From: Laura Gibbons <Laura.Gibbons@arun.gov.uk>
Sent: 16 November 2020 11:28
To: Planning.Responses <Planning.Responses@arun.gov.uk>
Cc: Raymond Cole <Raymond.Cole@arun.gov.uk>
Subject: BE/126/20/DOC and BE/127/20/DOC

Engineers Comments Regarding Condition 5 on BE/126/20/DOC and Condition 3 on BE/127/20/DOC

TITLE: ON-PLOT PROPOSED DRAINAGE LAYOUT

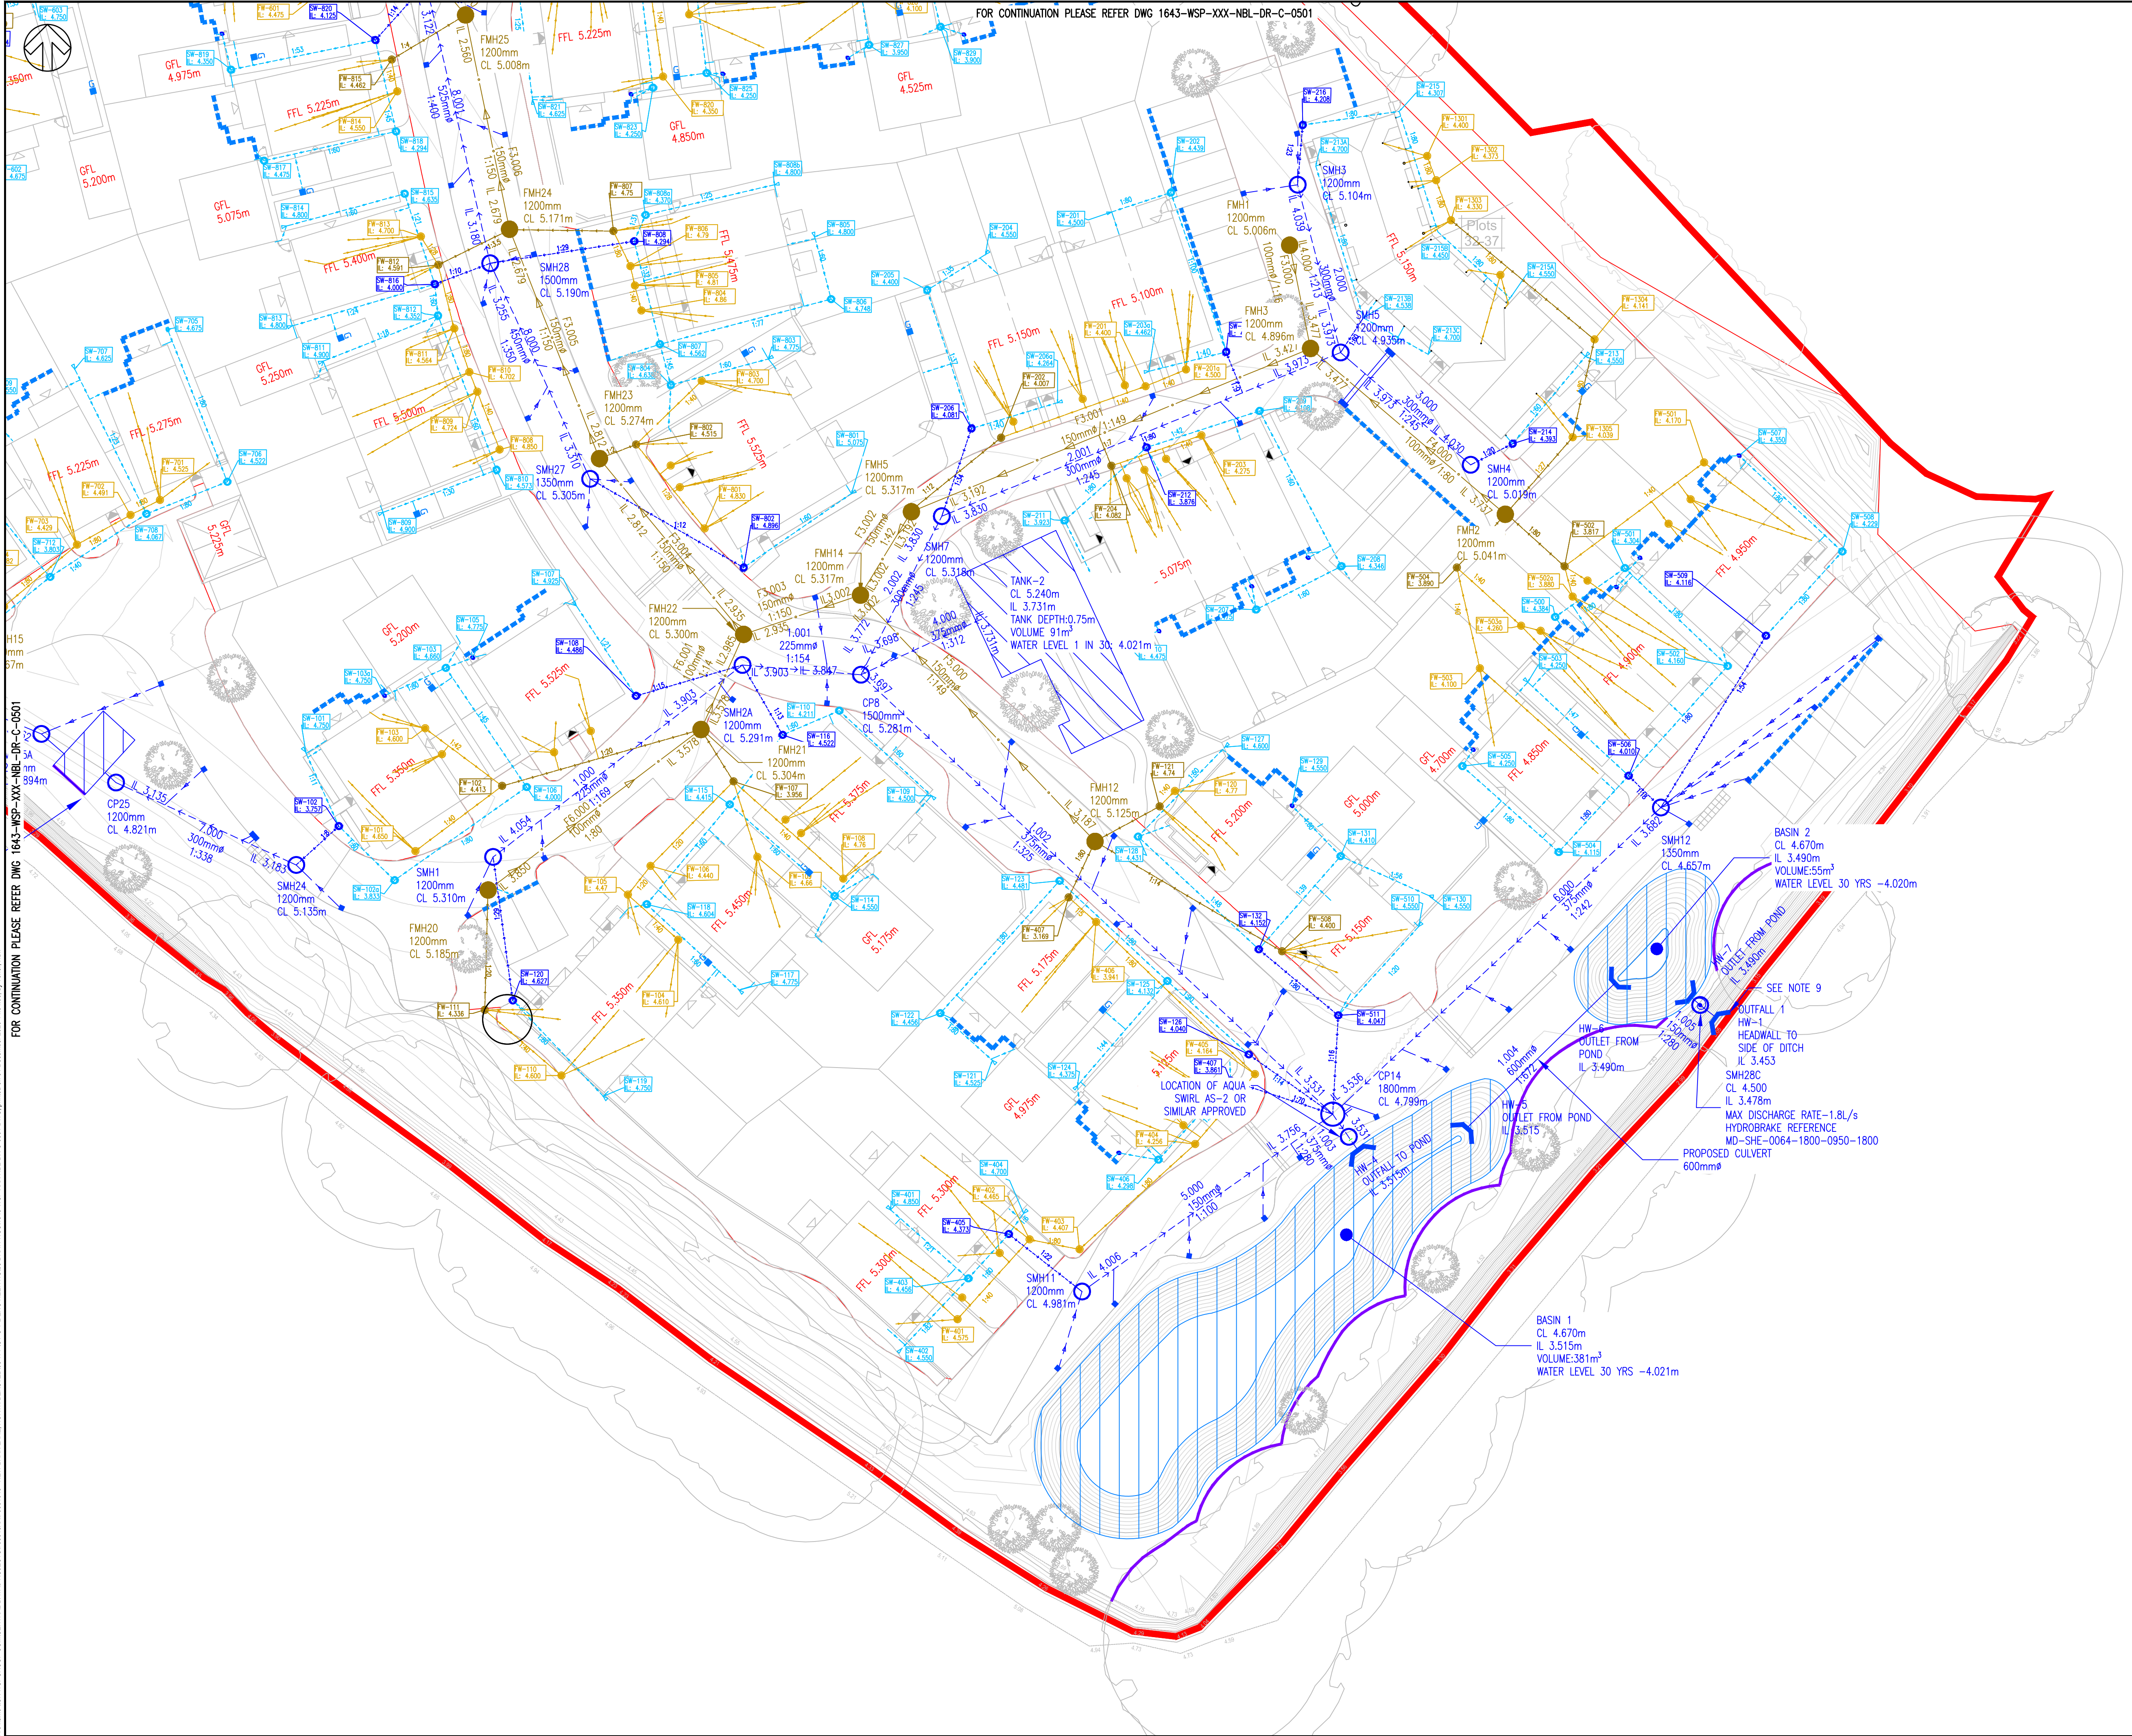
We confirm that we do not recommend discharge of the surface water drainage conditions at this time. Further discussions are required regarding the conflict between trees (both proposed and existing) and the proposed surface water drainage scheme.
